KIRKLEES METROPOLITAN COUNCIL INVESTMENT & REGENERATION SERVICE

Reference No:	2023/62/92450/E
Site Address:	1, Ridgeway Drive, Birstall, Batley, WF17 0NU
Description:	Erection of two storey side extension, single storey rear extension, dormer window to rear and front porch
Recommending Officer:	Nicole Helliwell

Officer Report

Drawn DRH
Date May 2023
Scales 1:100 @ A3
Drawing No. 22103 - 0301 - P04

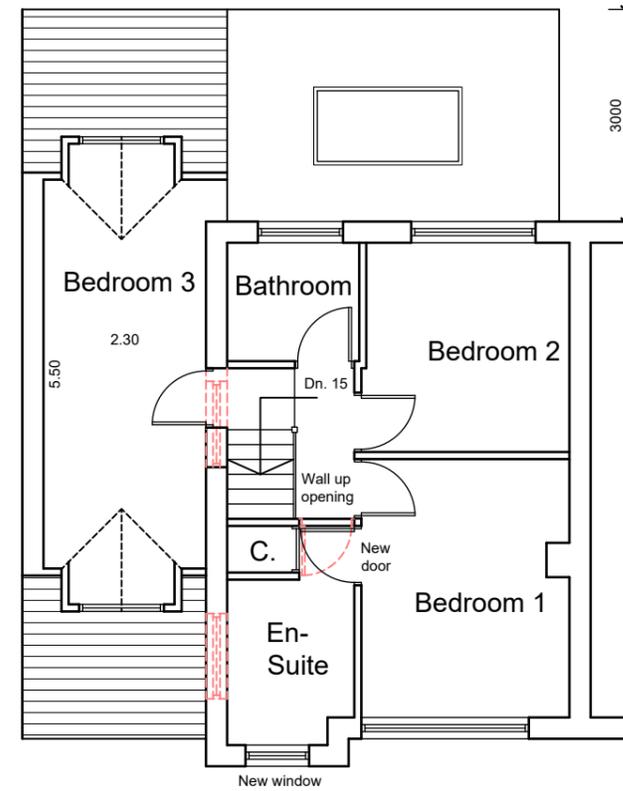
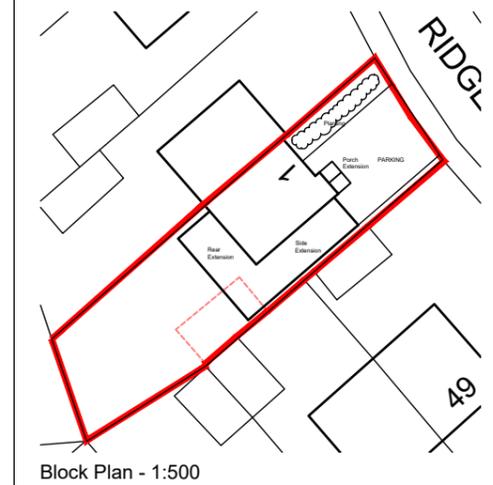
Amendments were sought during the course of the application. A request was made to omit the front dormer extension from the proposed two storey side extension. Revised drawings were received which were considered acceptable with regard to visual amenity.
